Ref: 20-413 – Planning Statement  
Revised 02.02.2021

## Planning Statement

Rear Extension at:  
9 Meadow End  
Bembridge  
PO35 5YB  
Isle of Wight

Title
Existing Elevations

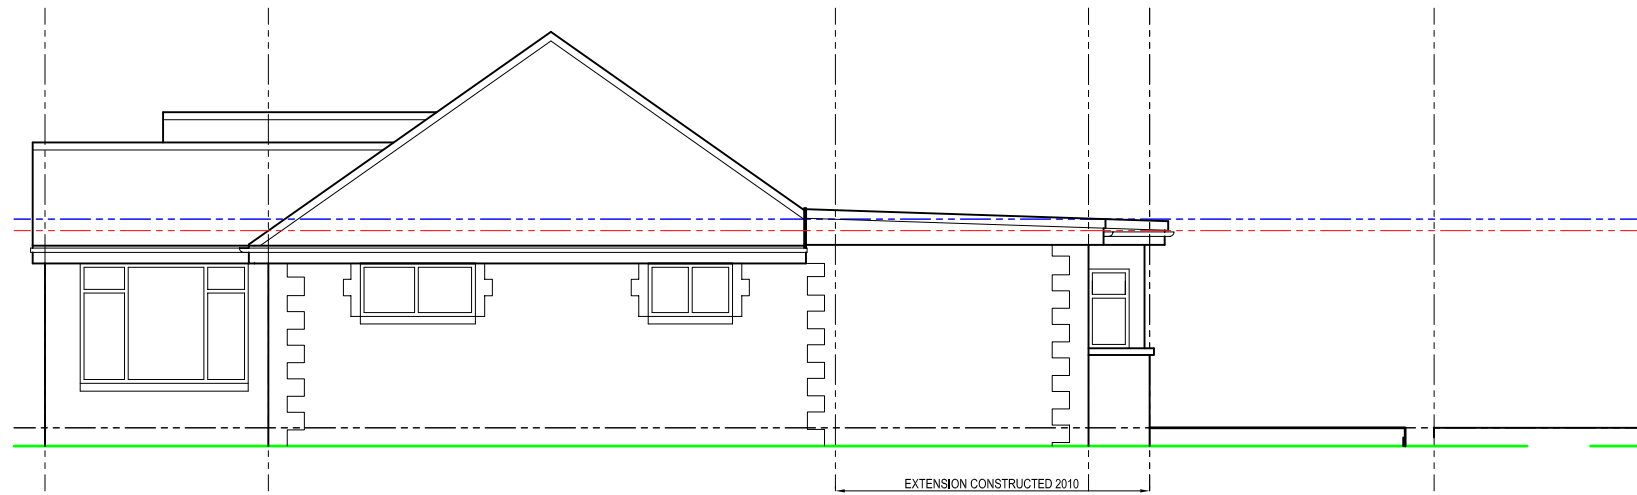
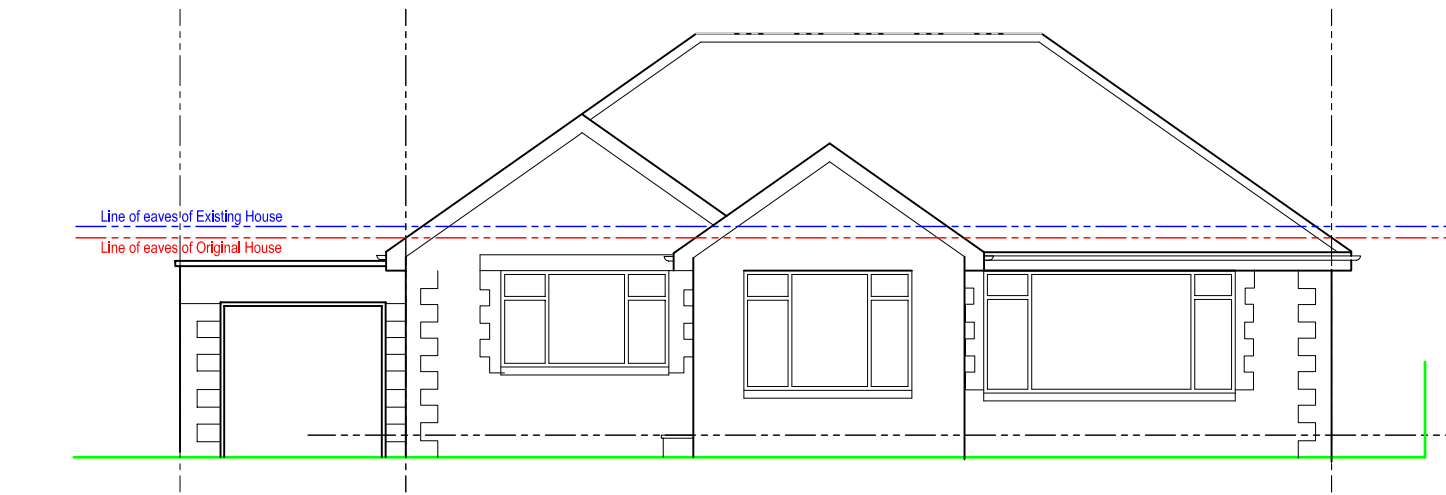
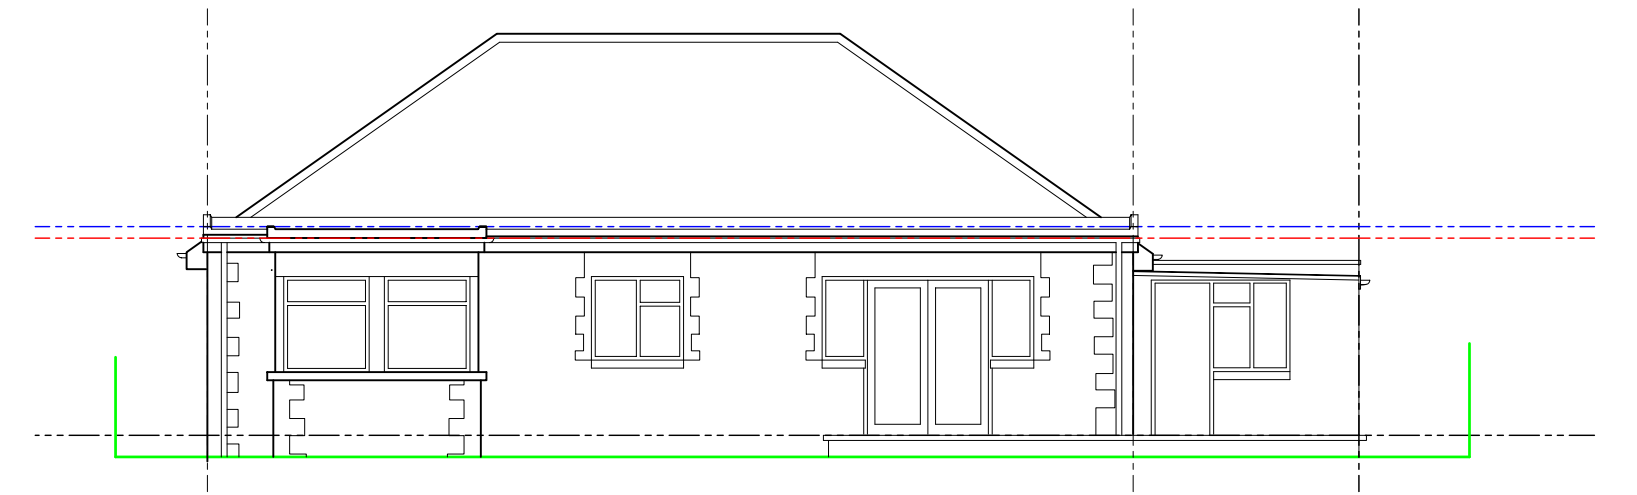
(d) The height of the eaves of the part of the dwellinghouse enlarged would not exceed the height of the eaves of the existing dwellinghouse. **DOES NOT COMPLY.**

2. The existing flat roof rear extension from the side. The line of these "existing eaves" height has been indicated on the revised drawings, as has the eaves line of the "original dwelling". The height of the eaves of the part of the dwellinghouse enlarged does not exceed the height of the eaves of the existing dwellinghouse.
